Portland Harbor Hotel Addition

MEMORANDUM

Subject: Application ID: 2007-0089

Date: 9/7/2007

8 | THIRD FLOOR PLAN  
SCALE: 1/8" = 1'-0"

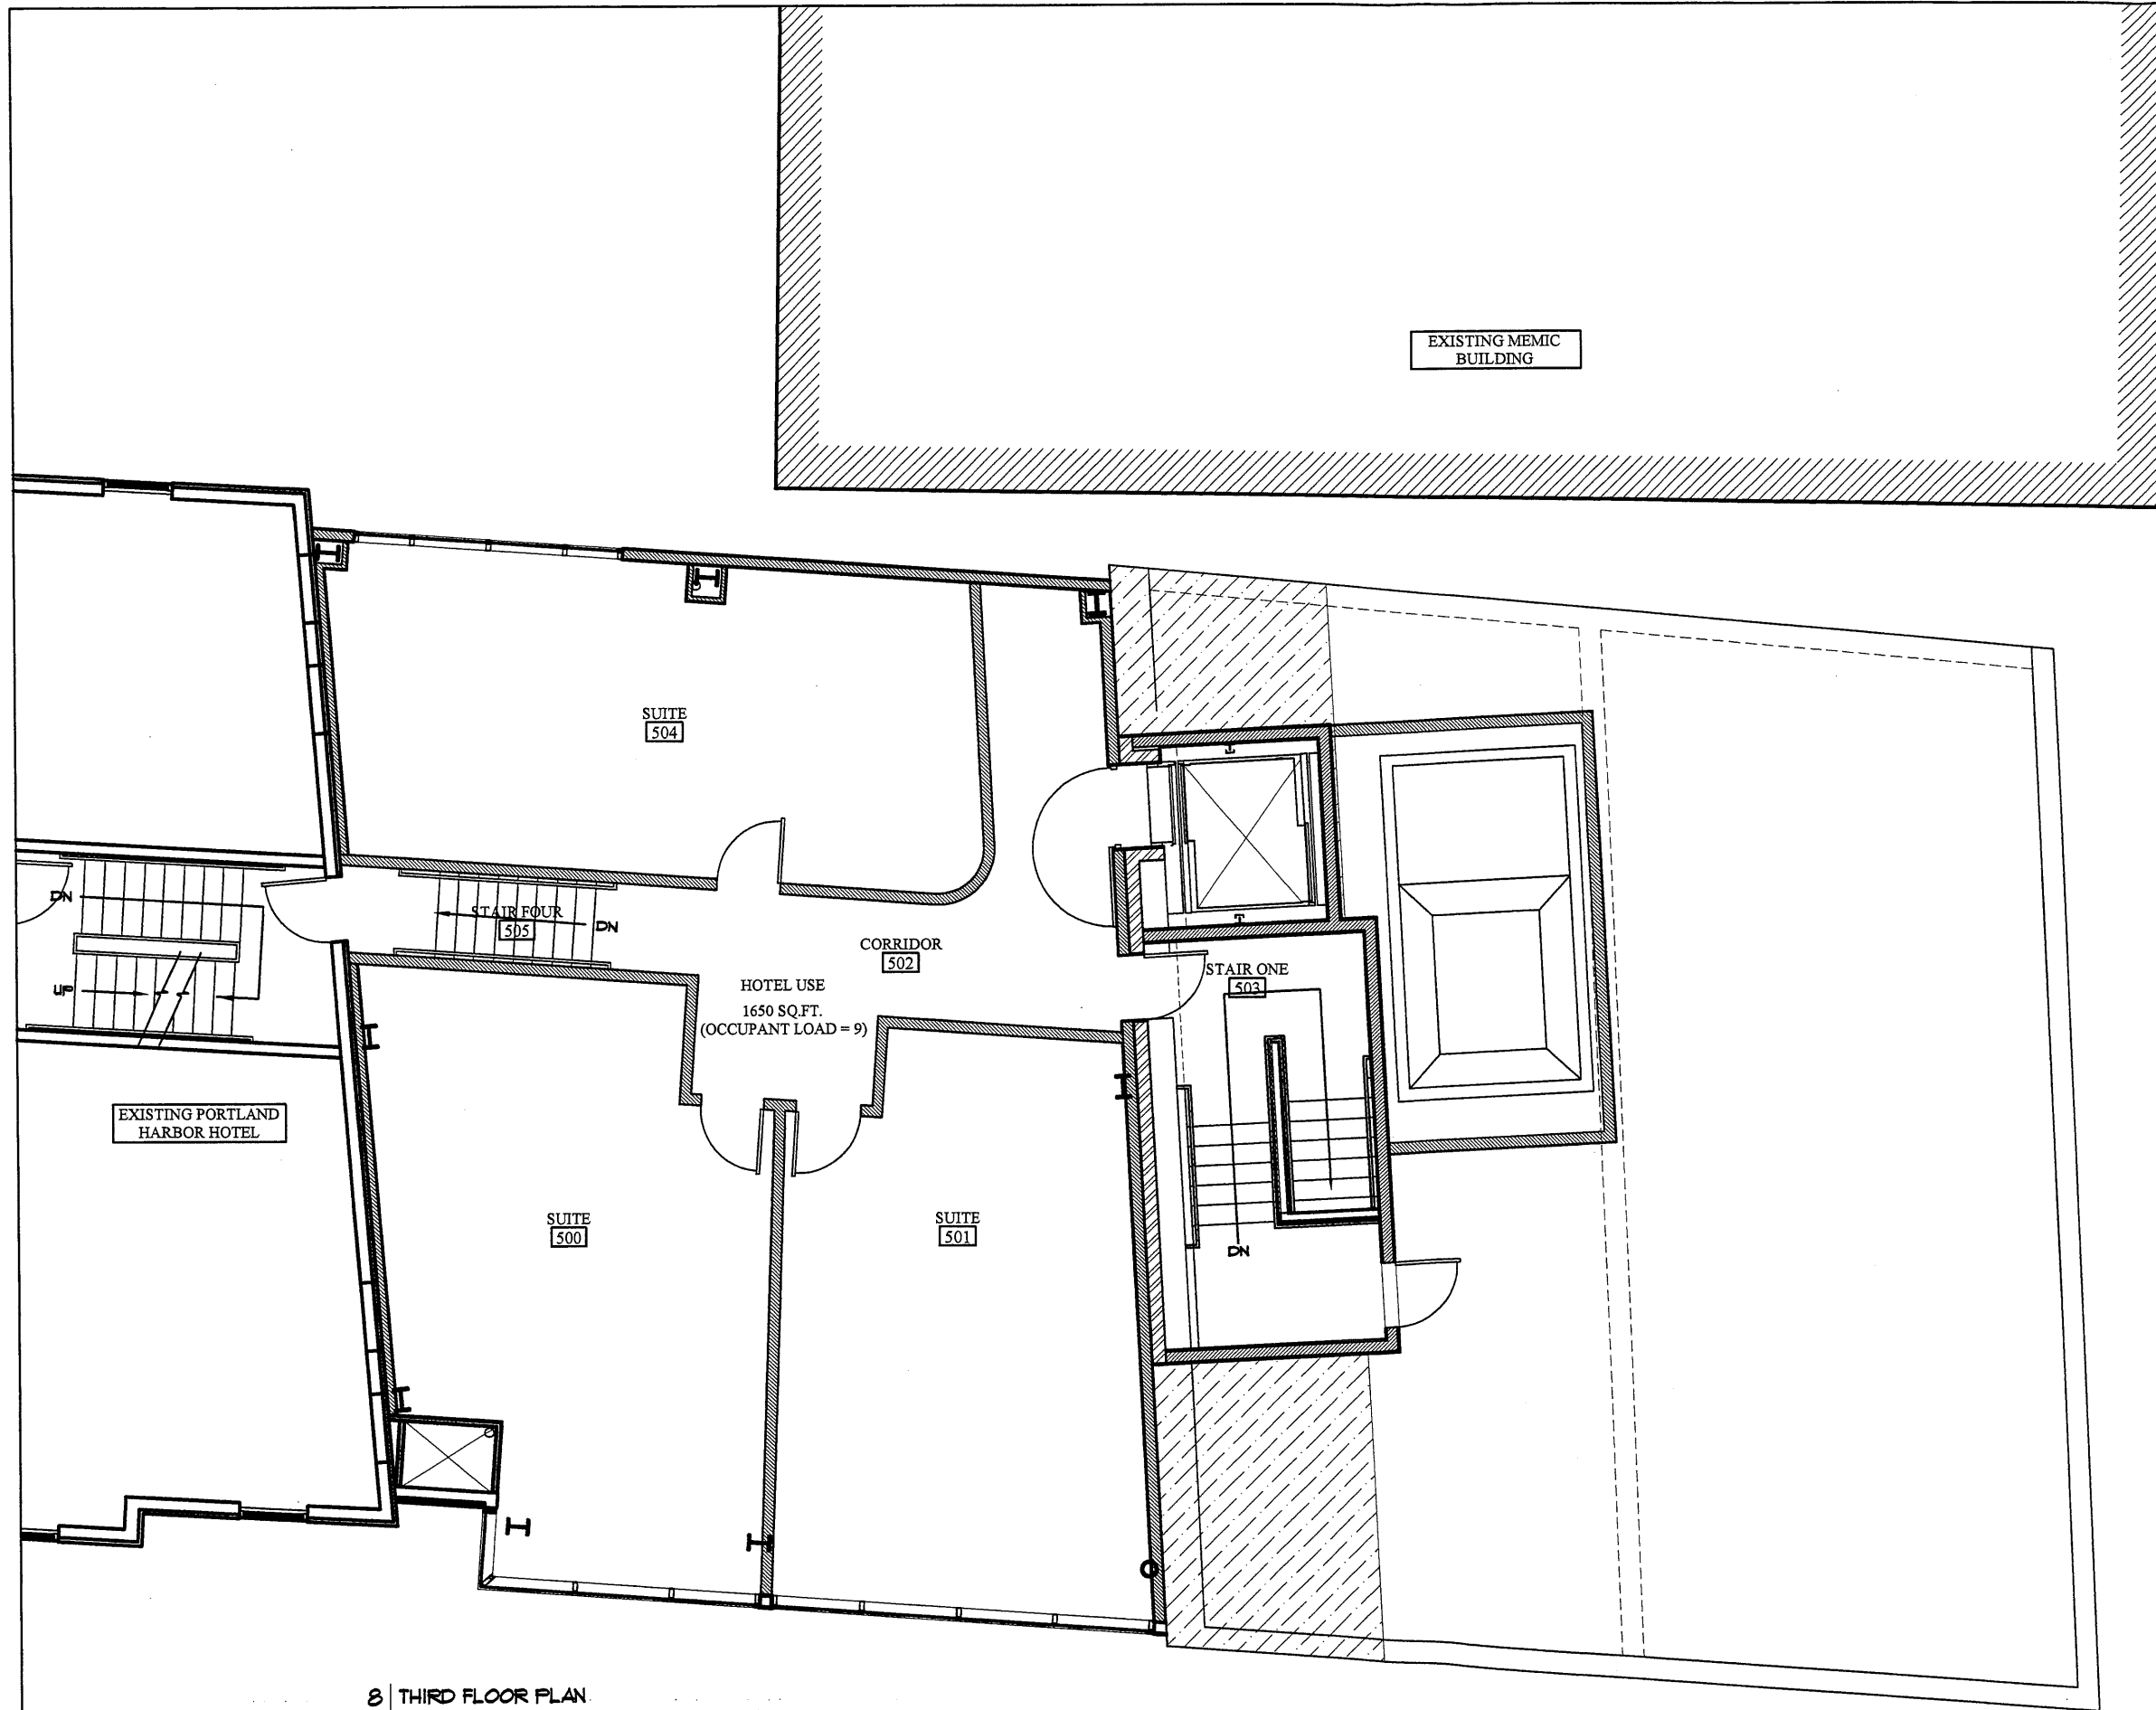
I have reviewed the floor plans received on August 29, 2007. My parking analysis of the new structure would require an additional 16 parking spaces. The parking study submitted on 5/31/2007 shows the existing parking capacity for the 16 addition parking spaces.

I have reviewed the basic submittal. I have noted that there are no floor plans to help determine uses and parking requirements. I do not agree with the methodology used to create the submitted parking analysis. The old Akari building was determined to be all retail in its past use. It was only partial retail with personal services throughout the upper floors. The wrong numbers from the parking section of the ordinance were used in this analysis. This being said, I agree with the bottom line that there is apparently a parking surplus that the proposed structure on site can use. I believe that the parking requirements are being met with this proposal. Only the new structure generates parking requirements. The change of use of the existing Akari building does not need to meet the parking requirements based upon the B-3 zone parking allowances.

I would like to see floor plans of the new structure and for the rehabbed Akari building to quantify the number of hotel rooms in total proposed.
